Application Reference: 2026/0217

Site Address: Cawthorne Old Barn, Brook Houses Taylor Hill, Cawthorne, Barnsley, S75 4EZ

Introduction: The proposal is for the erection of 1st floor side extension and front extension with rooflights to the front and rear.

<b>PLANNING</b>				
CLIENT Mr & Mrs Milner				
PROJECT Brook Houses, Cawthorne				
TITLE Proposed Elevations				
CREATION DATE Mar 2026	SCALE @ A1 1 : 50	DRAWN CW	CHECKED CW	STATUS 53
SHEET NO. MILNER - CW - B01 - XX - DR - A - 10-201	REVISION 1

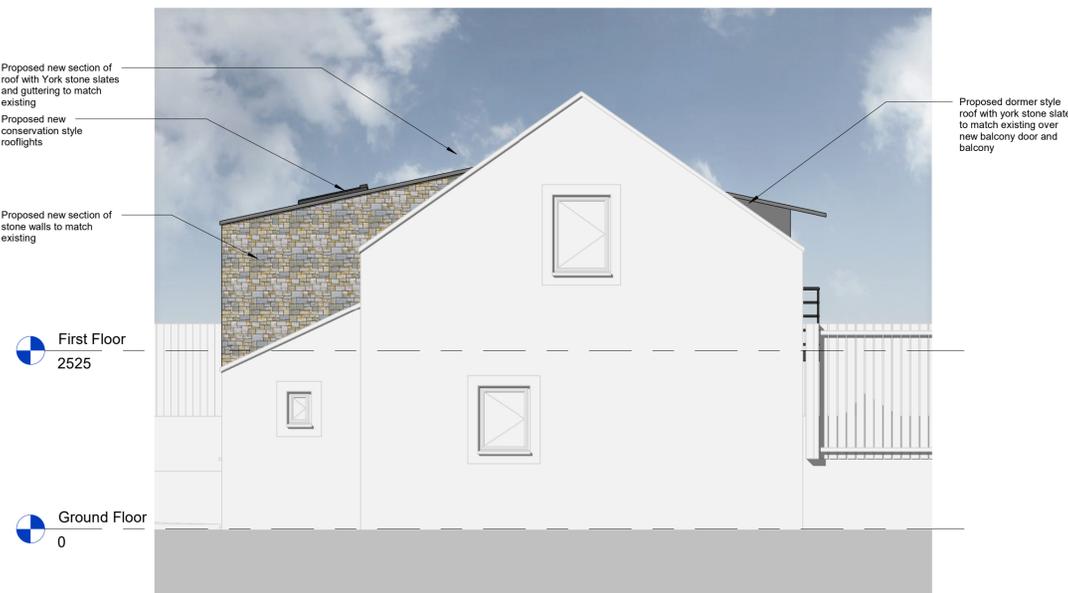
The original proposal included a first-floor side extension and two-storey front extension and balcony and these were considered unacceptable by the Conservation Officer. The changes

originally proposed would have resulted in an alteration that was unsympathetic to the character of the converted barn

Concerns have been raised by a neighbouring resident with regard to the design and impact of the original proposal upon privacy by way of overlooking. The proposal has now been amended and reduced with the removal of the balcony and the introduction of a catslide roof, which is of an improved design and further reduces any overbearing impacts to the neighbouring dwellings.

The proposal has been amended during the course of the application and a catslide roof now proposed with the removal of the previously proposed balcony in place of velux conservation Juliet style rooflights.

It was acknowledged that an extension to the first floor of the building is not unacceptable in principle as a previous planning application was granted in 2013 (Ref. 2013/1061) for the erection of a first-floor side extension. The proposal has been amended during the course of the application at the request of the Conservation Officer. The applicant has put forward a more appropriate proposal, which better respects the architectural and historic interest of the Old Barn (circa 1850), as well as the character and appearance of the Cawthorne conservation area. This has been achieved through the introduction of a catslide roof, the replacement of the balcony with conservation rooflights, and an overall design approach that reflects a more traditional appearance in keeping with the original building.

The Conservation Officer has confirmed that the revised scheme is therefore considered acceptable and conditions have been recommended in terms of the proposed stonework, windows, rainwater goods, and roof materials. The revised proposal is now considered to be in compliance with Policy HE1 and D1 of the Local Plan, the SPD's and the Cawthorne Parish NDP and significant weight has been given to the improved design the impact on the character of the Conservation Area.

CREATION DATE	SCALE @ A1	DRN	CHK	STATUS
Mar 2026	As Indicated	CW	CW	S3
SHEET NO.	MILNER - CW - B01 - XX - DR - A - 10-101		REVISION	
			2

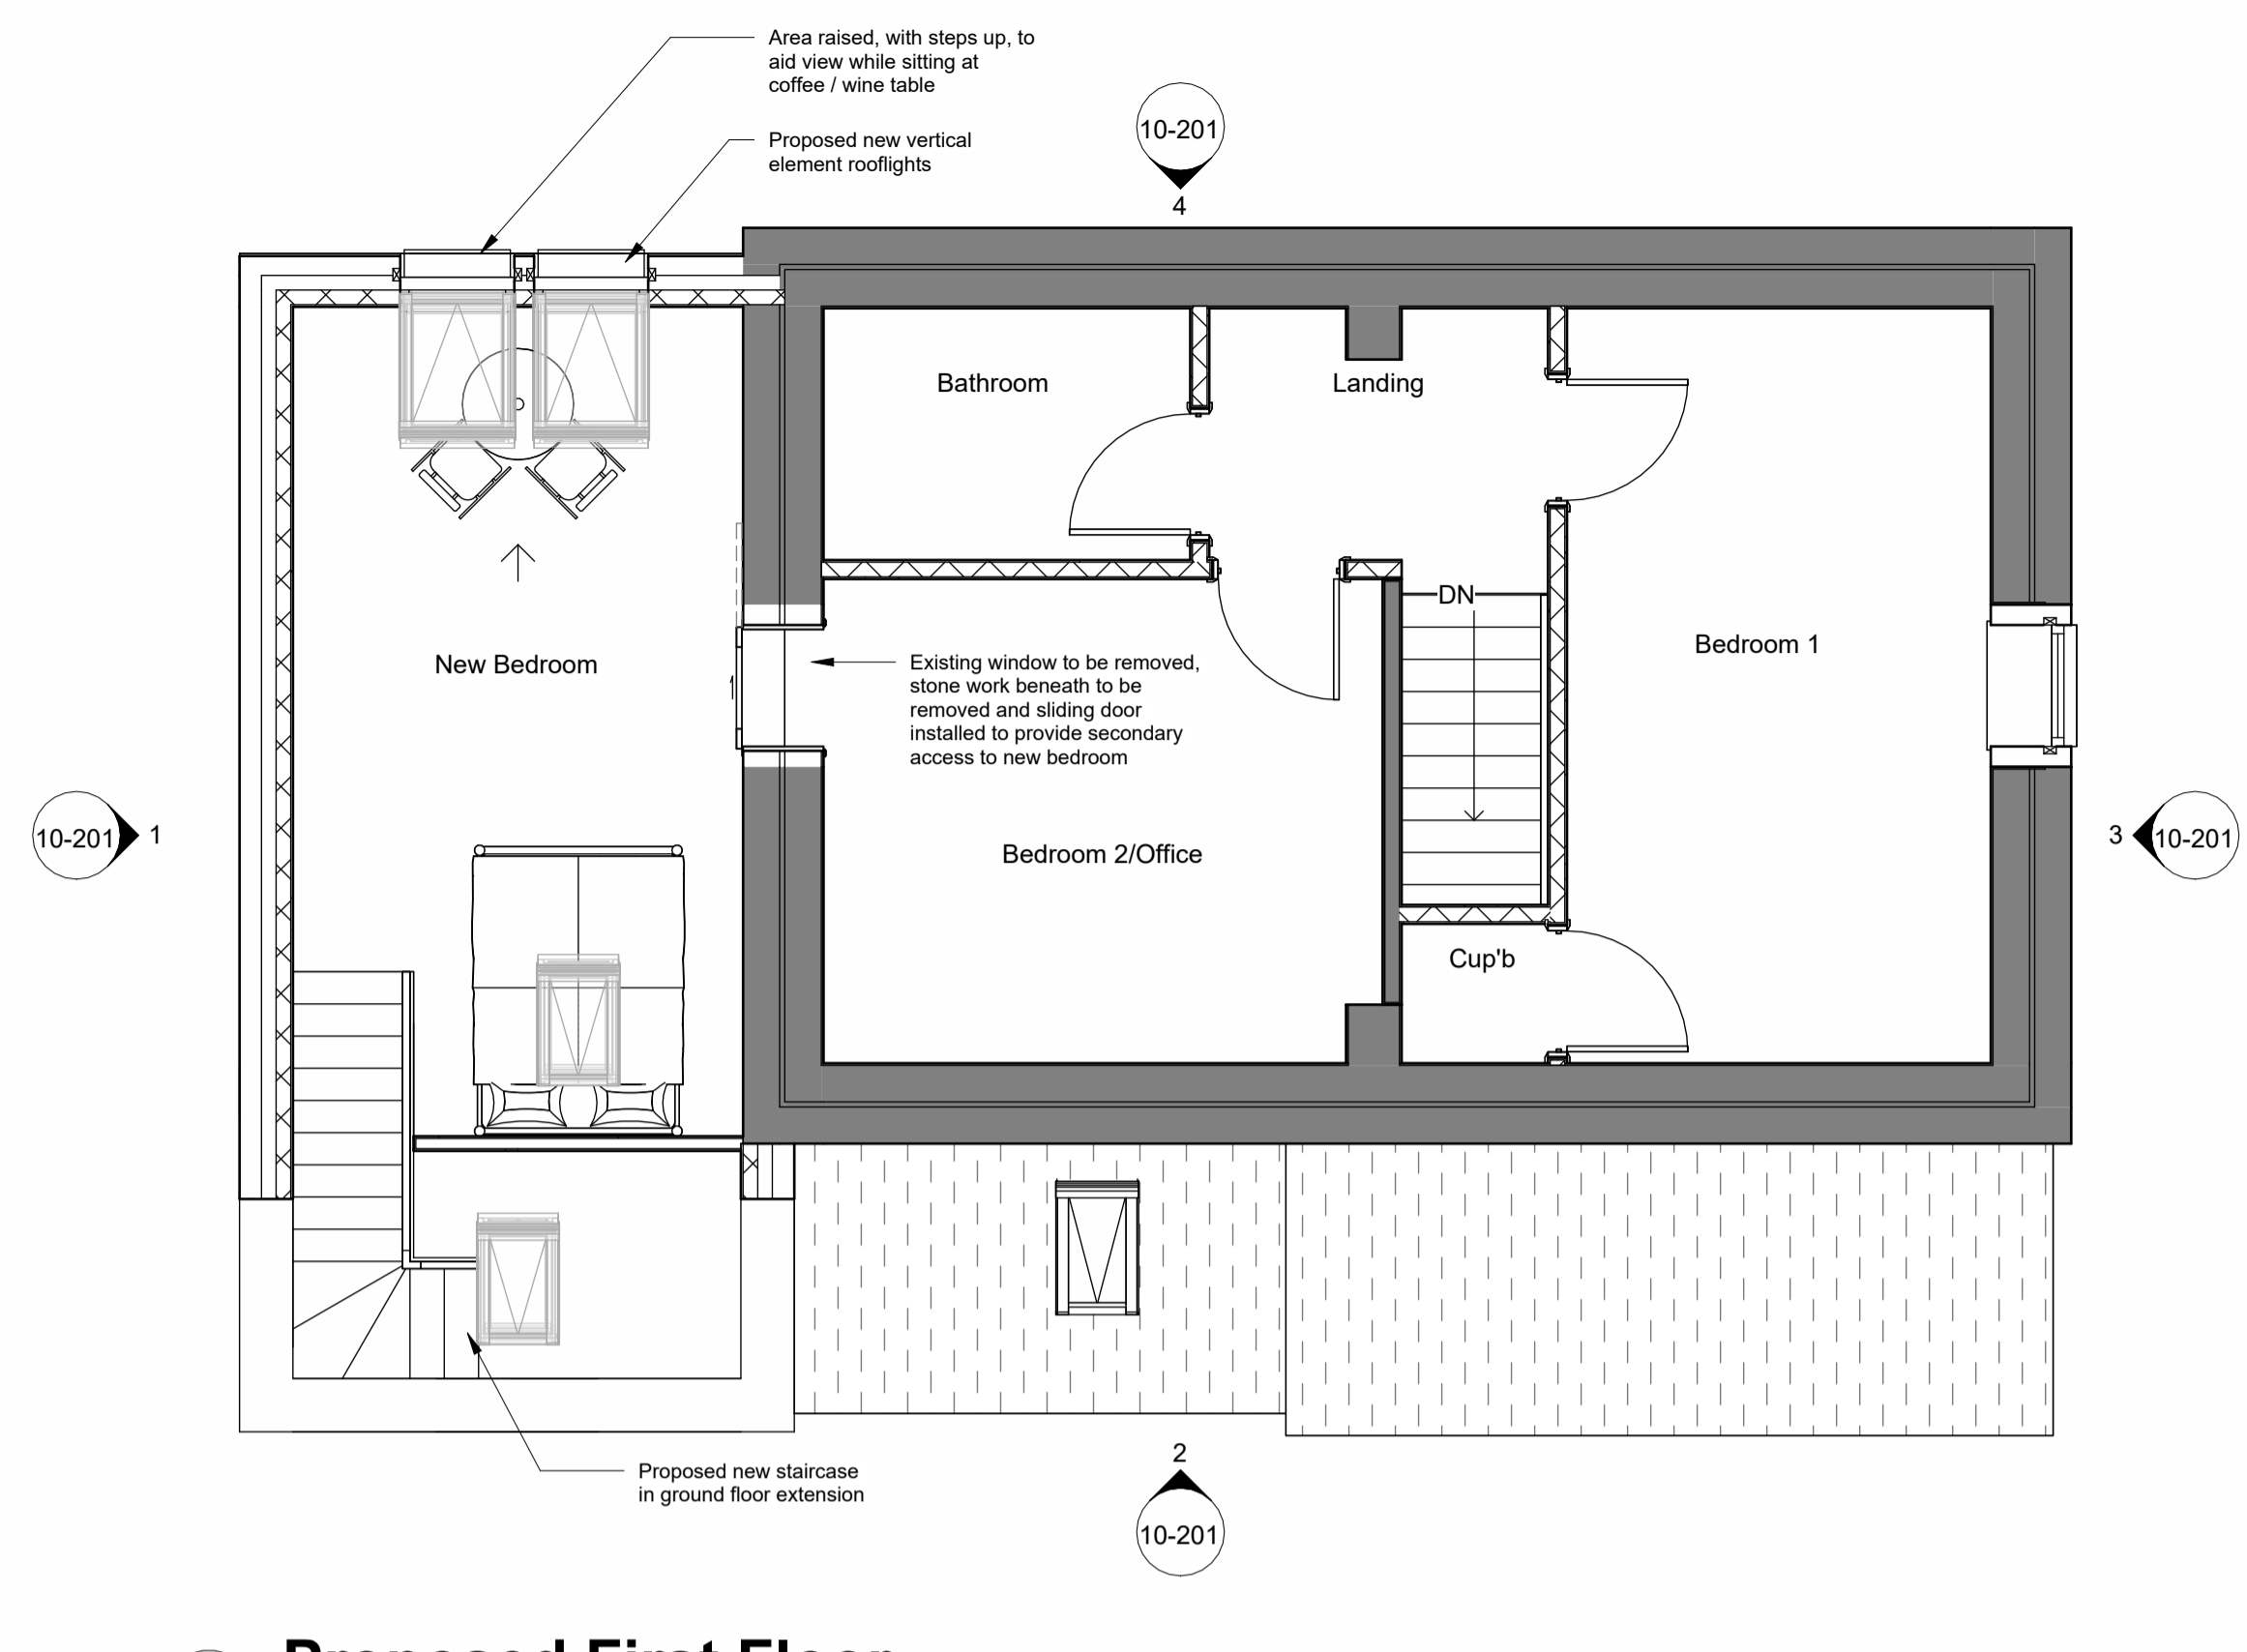
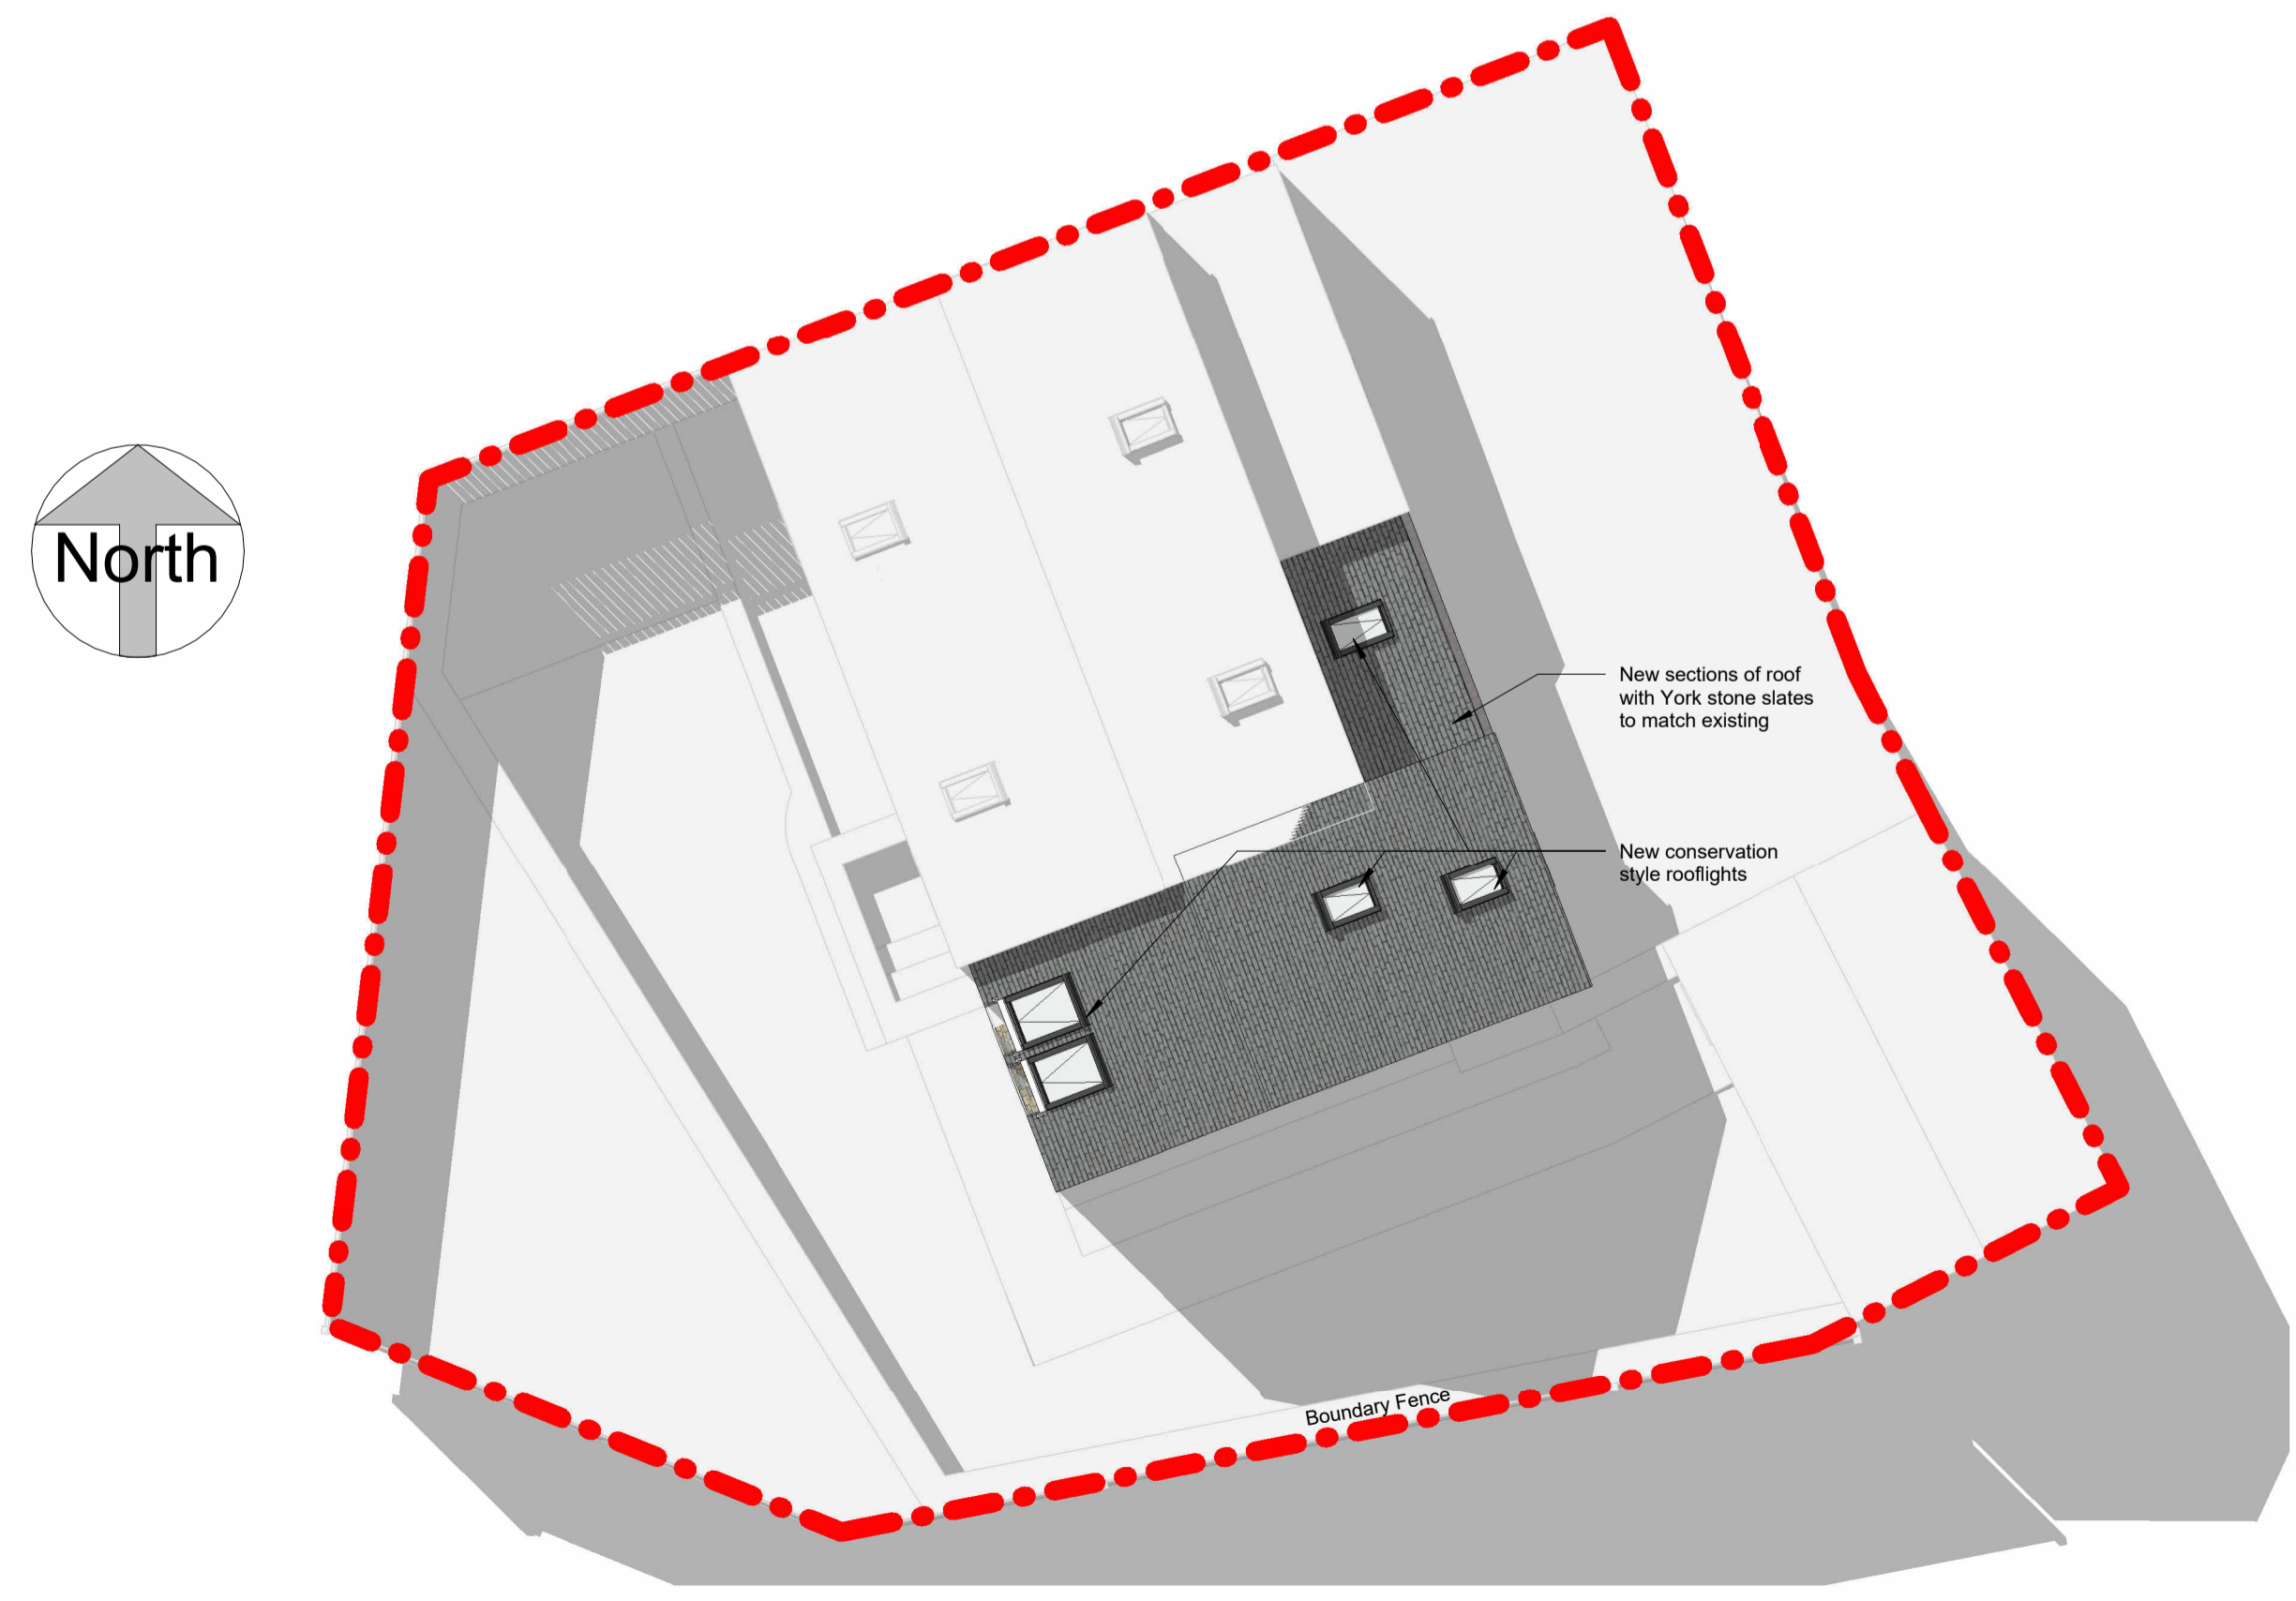
The proposal involves the erection of 1st floor side extension and front extension with rooflights to the front and rear. The proposal would provide an additional bedroom at first floor and staircase and access at ground floor level. The extension has been designed with a lowered roofline and a catslide roof to the 1st floor element which extends to the front, along with a single storey front extension.
